ABP / MCC / Irish Water Consultation Summary

Dunshaughlin East SHD

Doc No. WS-01 Rev A (07/12/18)

CLIENT Rocktore 1 Limited	TITLE Attenuation Details - Storm Catchment No. 1
PROJECT Proposed Strategic Housing Development at Dunshaughlin East	SCALE As Shown @ A1
DATE Nov 2018	DRAWN BY: SC
CHECKED BY: PC	JOB No. J18-001
REV A	DRAWING No. 021

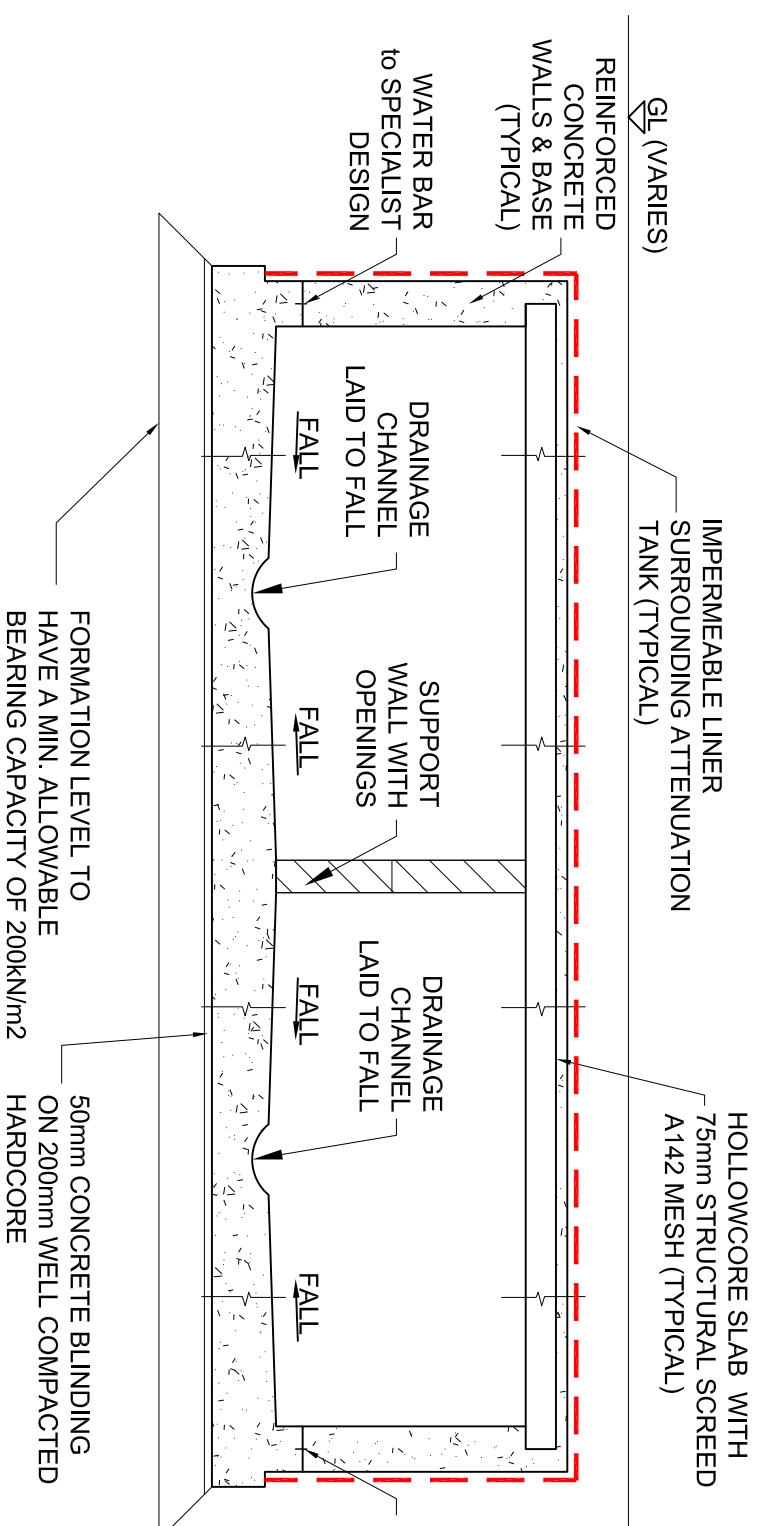
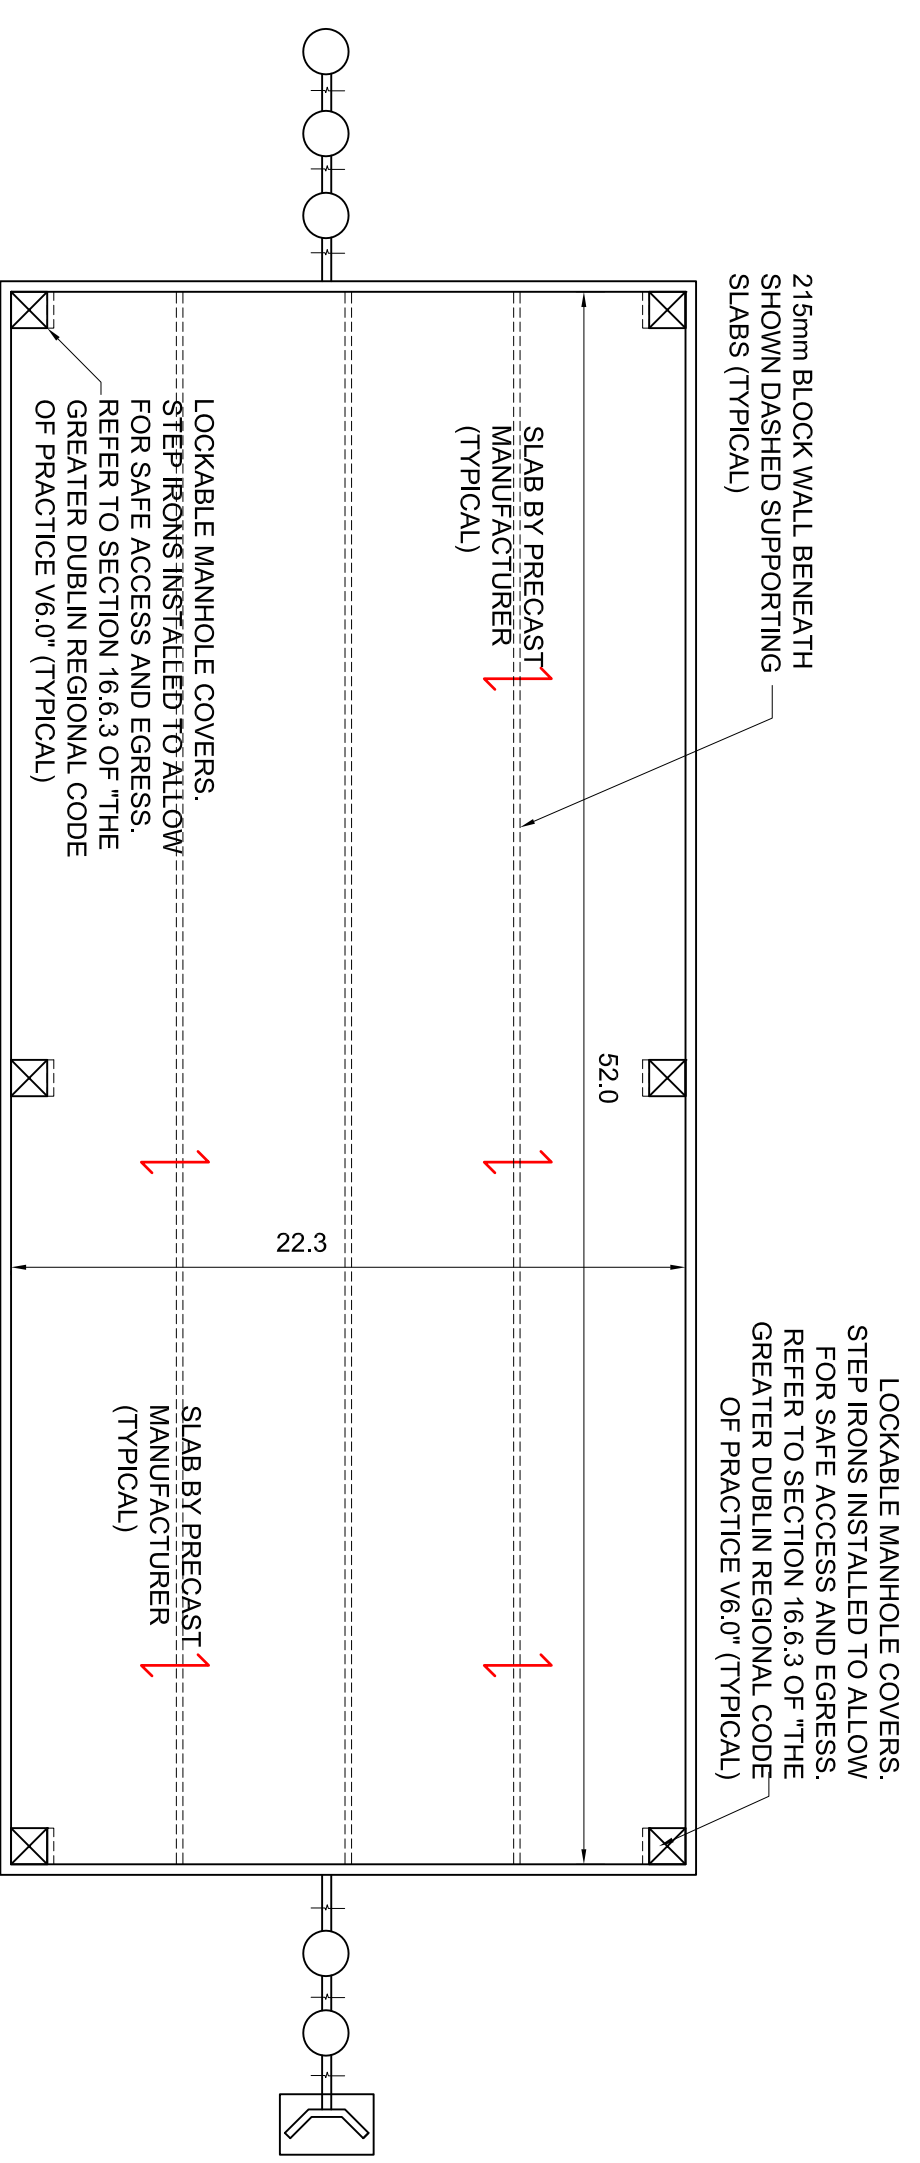
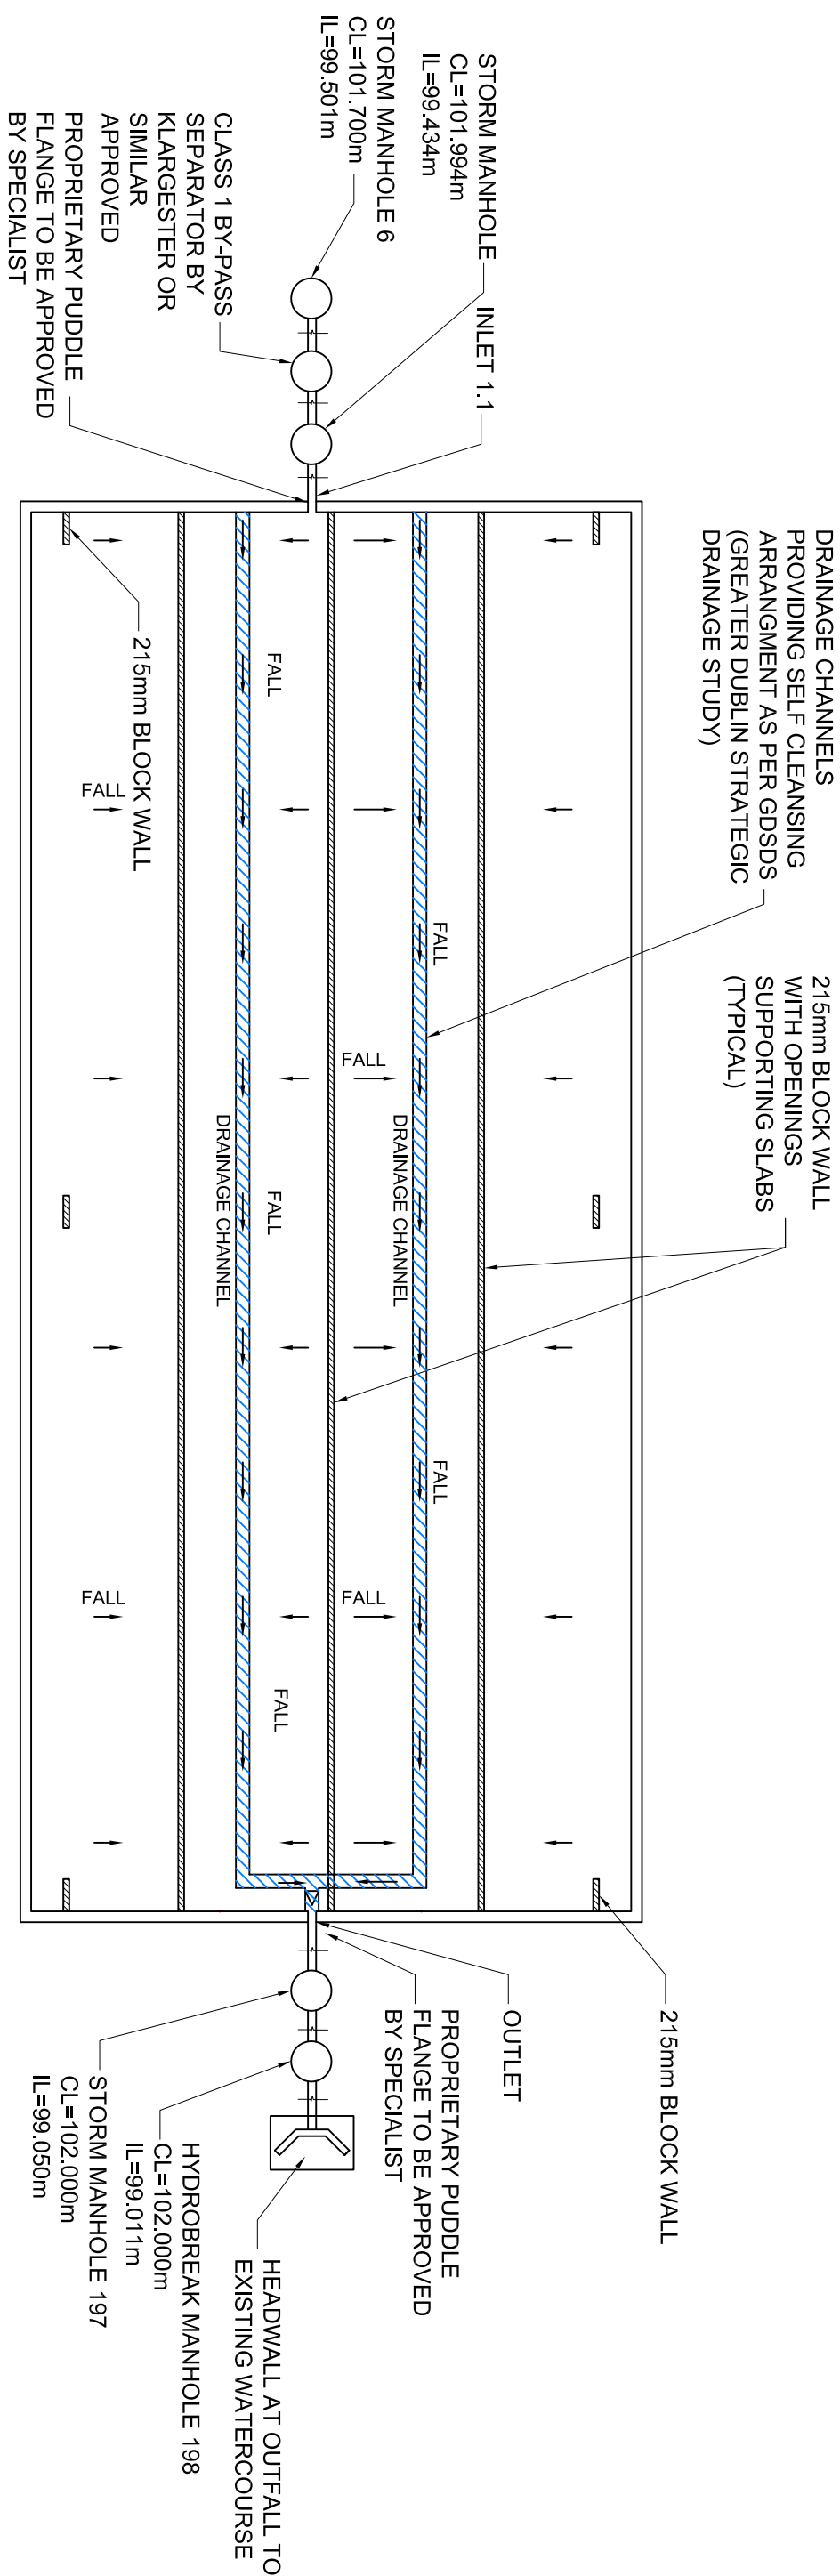
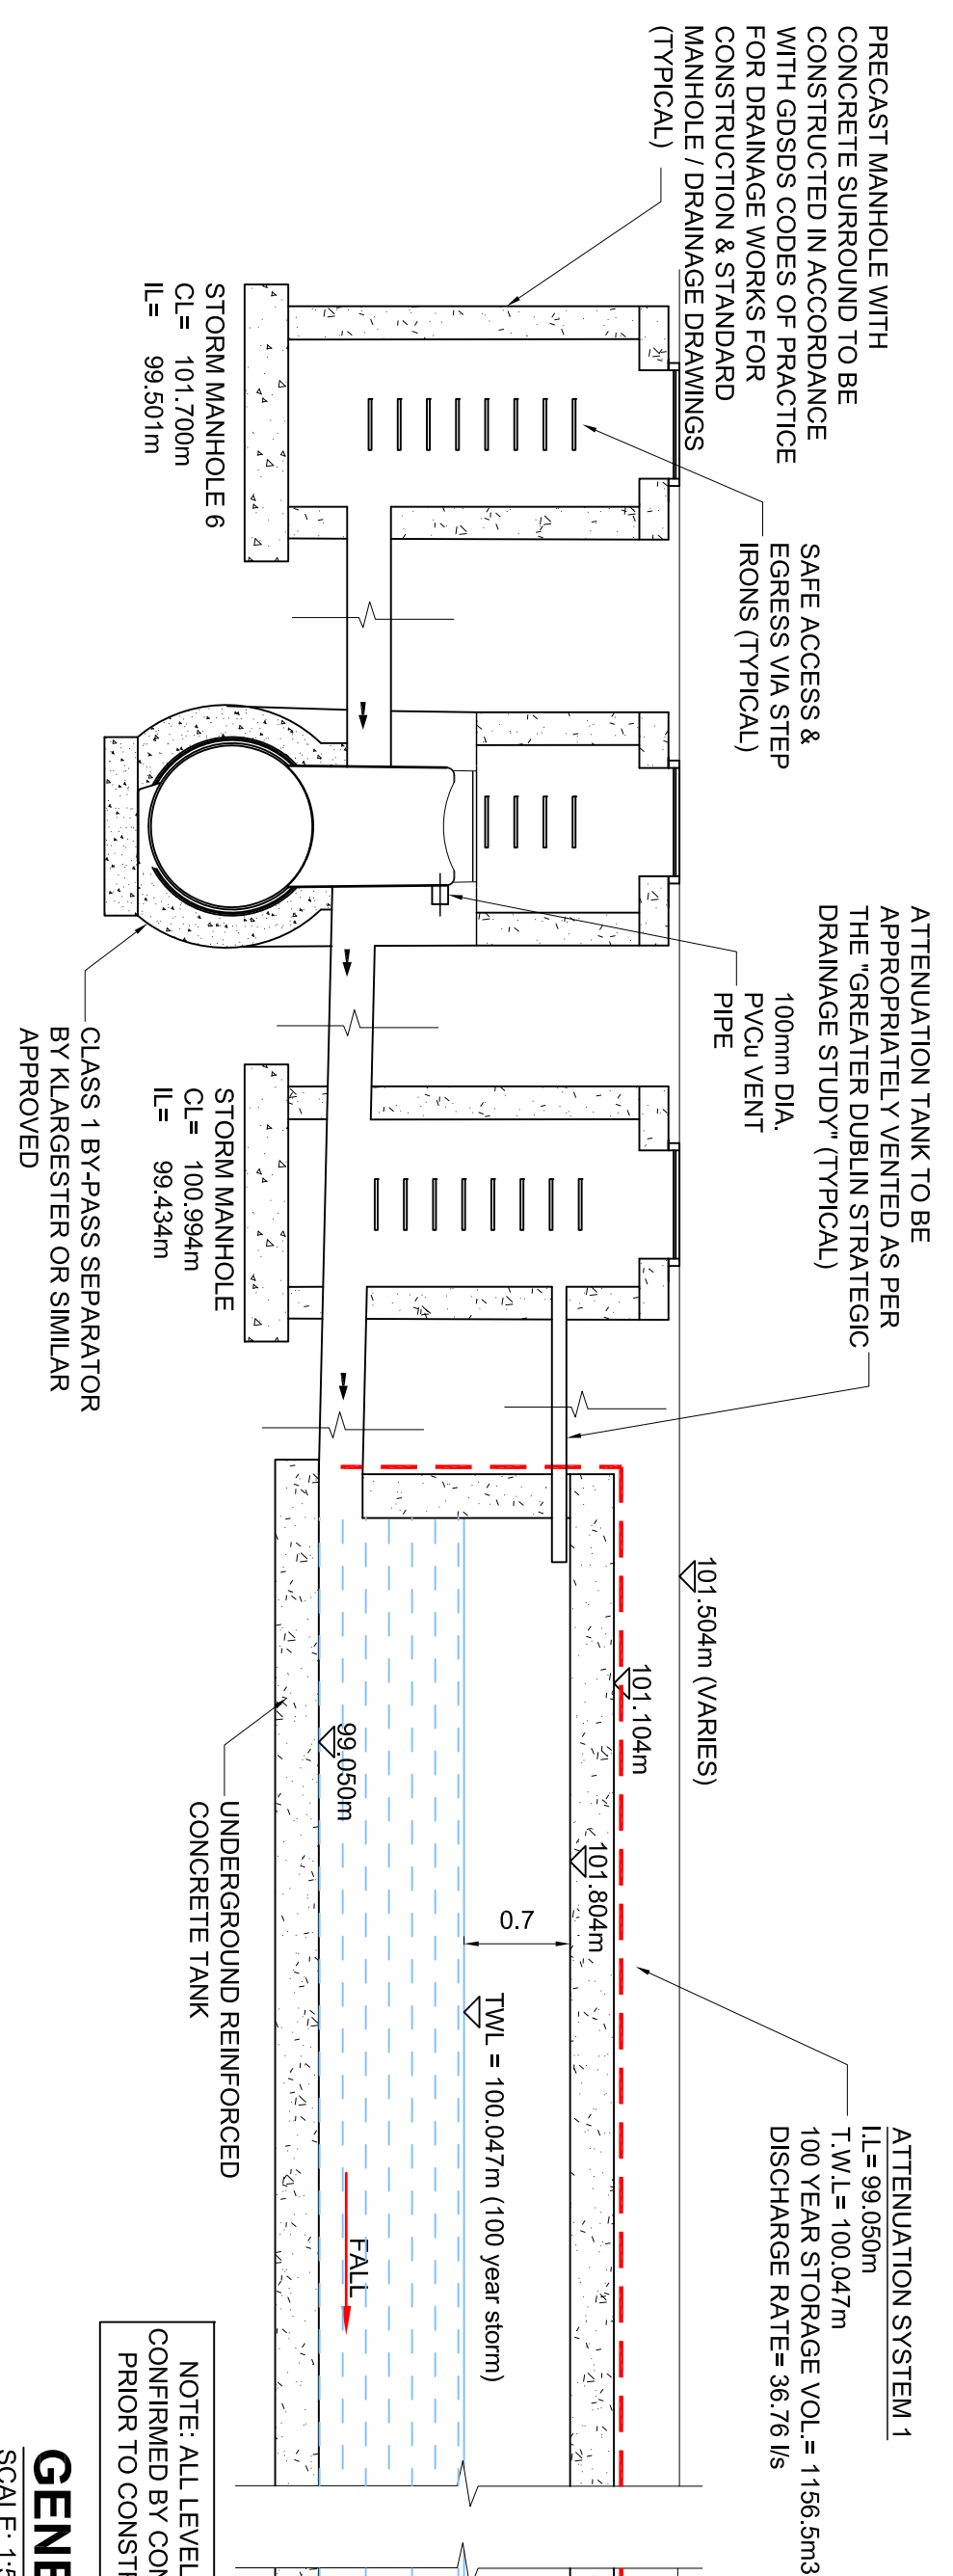
4. Prior to commencing construction the applicant shall submit results of the ground water level monitoring at each of the proposed attenuation sites. The water table level shall be clearly indicated relative to the proposed attenuation system invert level and appropriate measures implemented to ensure the attenuation system does not become inundated with ground water. The proposed attenuation system shall be acceptable to the MCC Water Services Engineer.

1. All surface water drainage design shall comply fully with the Greater Dublin Strategic Drainage Study (GSDSDS) Regional Drainage Policies Volume 2, for New Developments.
2. Permeable paving omitted from public car park spaces and shown in privately owned car parking spaces only.
3. The applicant shall install a non-return valve on the proposed discharge Outfall No.2. Prior to construction the applicant shall submit details for the non-return valve which shall be acceptable to MCC Water Services Engineer
4. Following consultation with MCC and reviewing initial results from the ground water level monitoring process it was concluded that a fully sealed attenuation system was required due to high ground water levels. With regards this the preferred attenuation system of MCC was underground concrete tanks.
